From: Amanda Scholes on behalf of Planning.Responses
Sent: 27 April 2018 08:19
To: Planning Scanning
Subject: FW: 1 Seaton Road LU/33/18/HH

From: Mark Jones [REDACTED]
Date: 20 April 2018 at 12:13:18 EEST
[REDACTED]
Subject: 1 Seaton Road LU/33/18/HH

1801/006

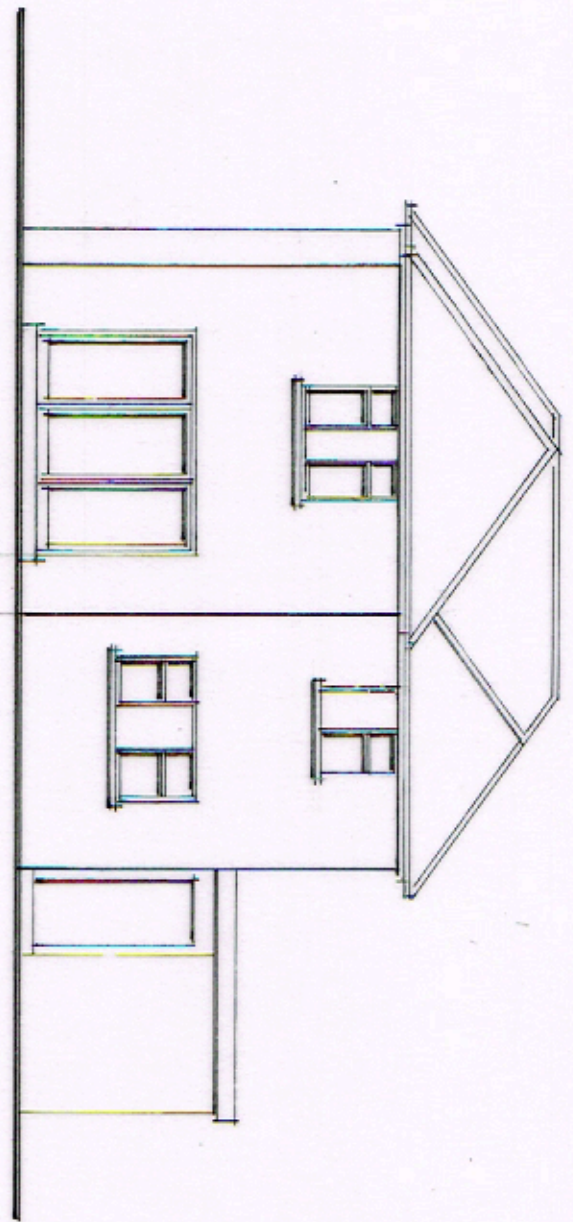
The neighbouring property No.3 has what appears to be a bedroom window in rear elevation set back behind the rear building line of No.1. My concern is the impact of the two storey extension on the this habitable room. To assess such matters the Council usually take a 45 degree line off the centre point of the nearest window. In this case this line is breached and I feel that the two storey extension

will have an adverse impact upon this window and the amenity of the adjoining occupiers.

1801/005

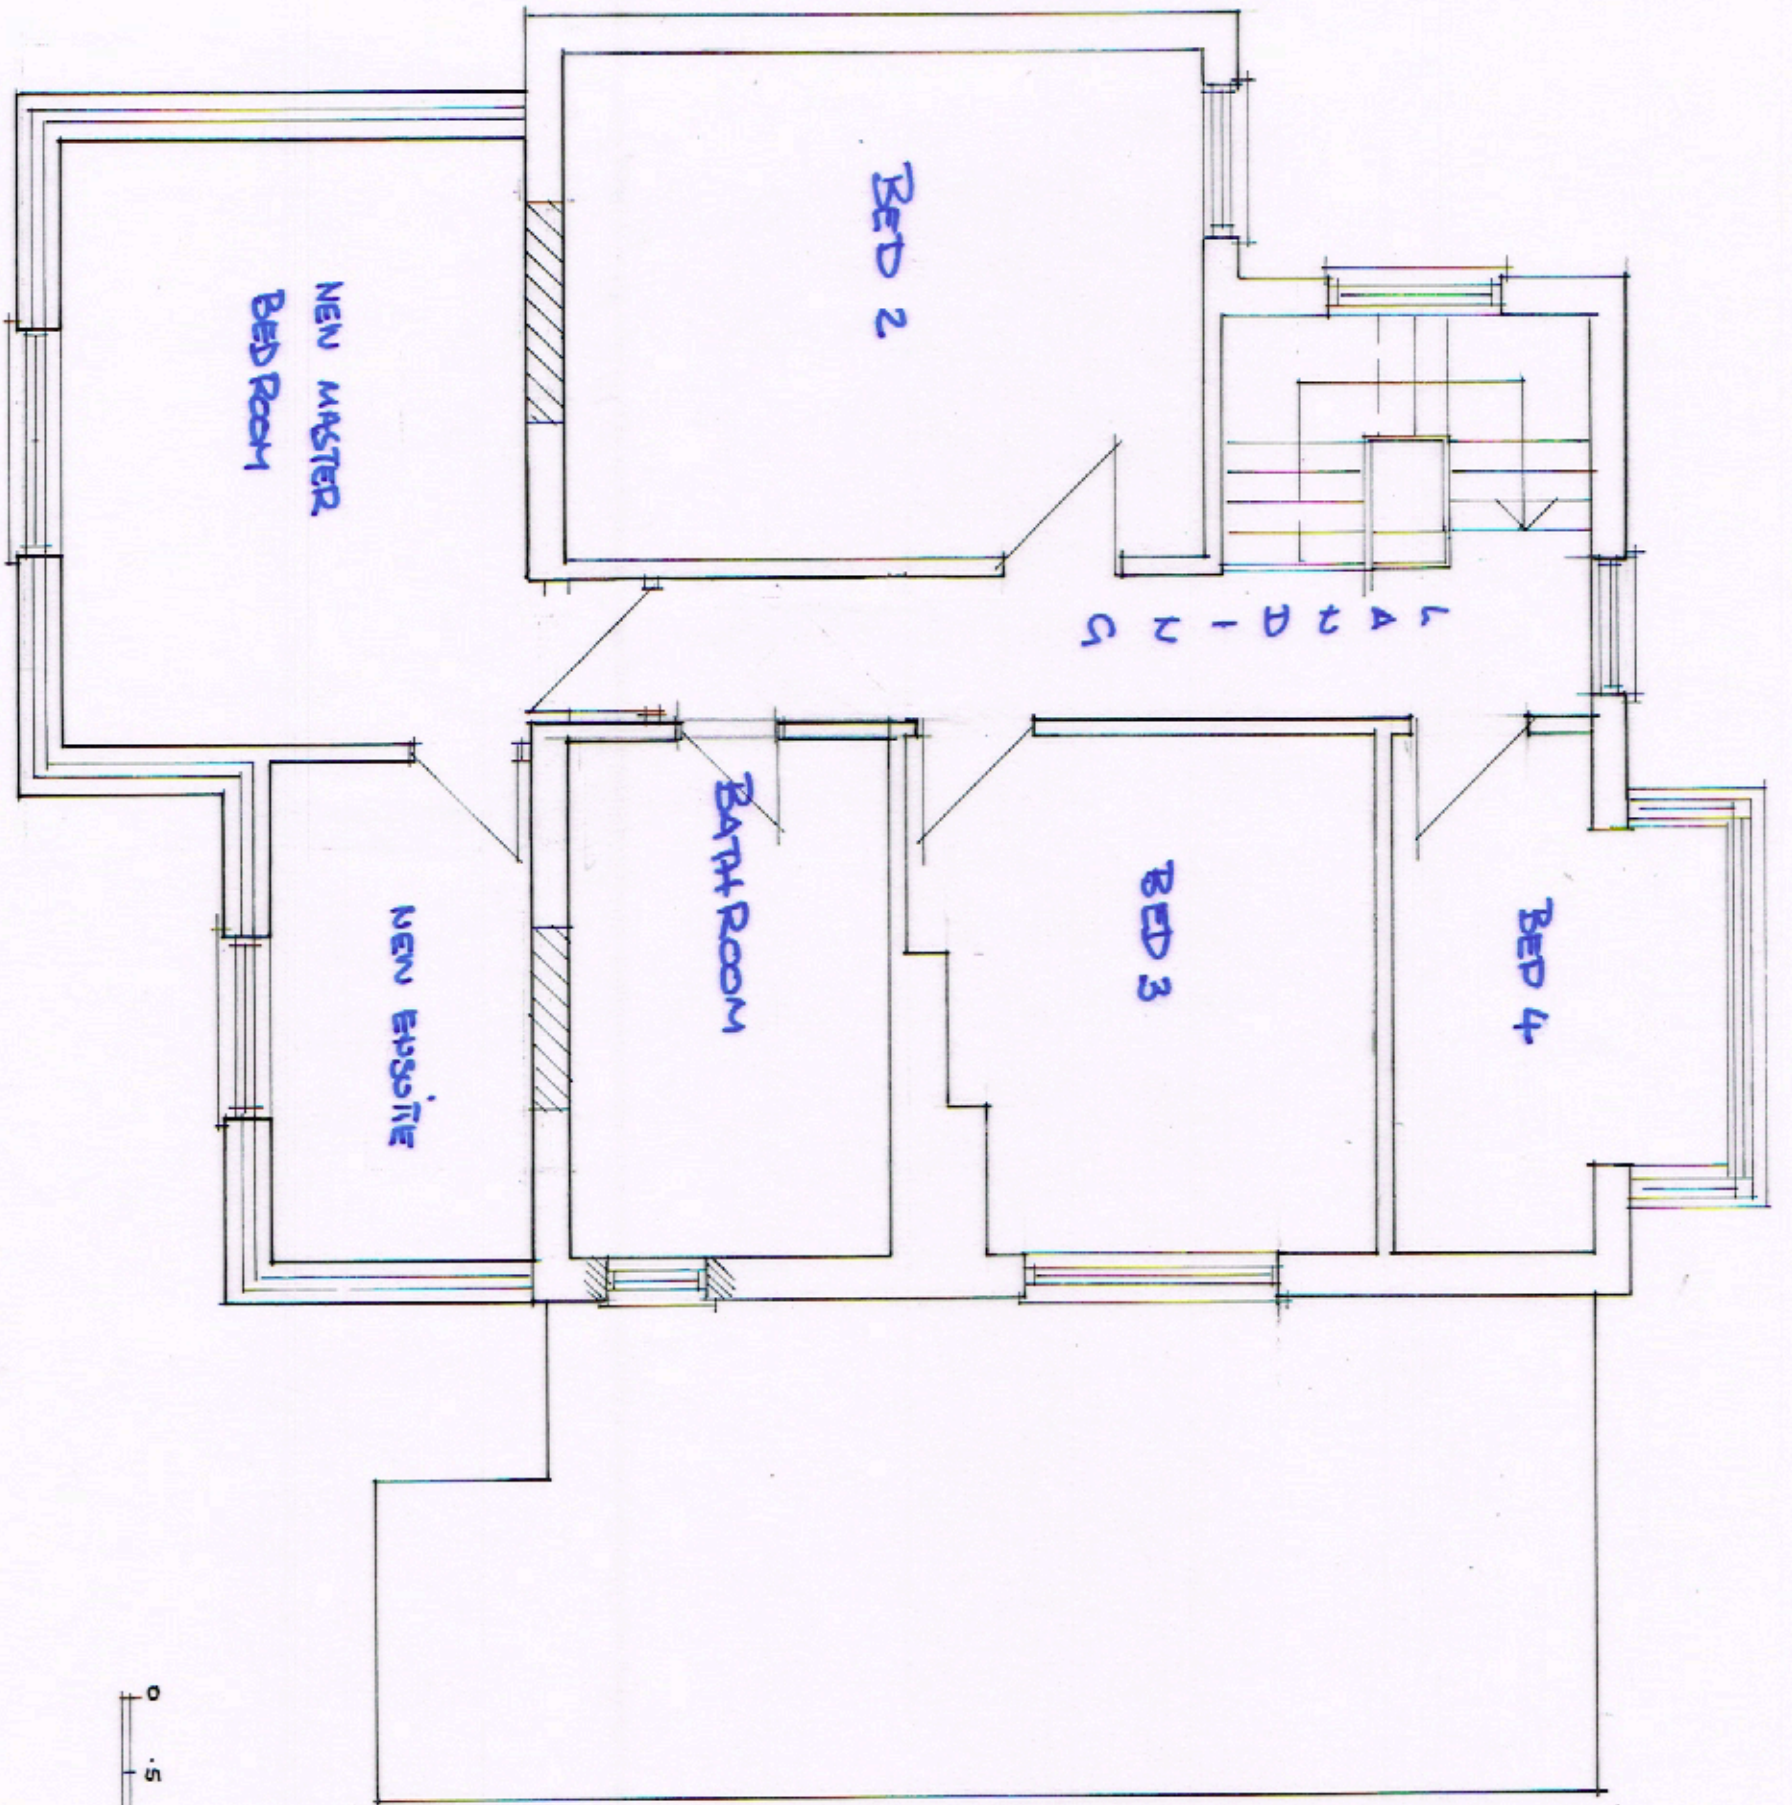
I would welcome your comments on this issue or if possible if the scheme can be amended to address this issue, I appreciate you will need to speak to your client on this matter. I can agree an extension of time to determine the application and suggest we can discuss this if the scheme is to be amended or we can agree an extension of time until 4 May to allow you to consider this. If resolved before this date we would obviously determine sooner
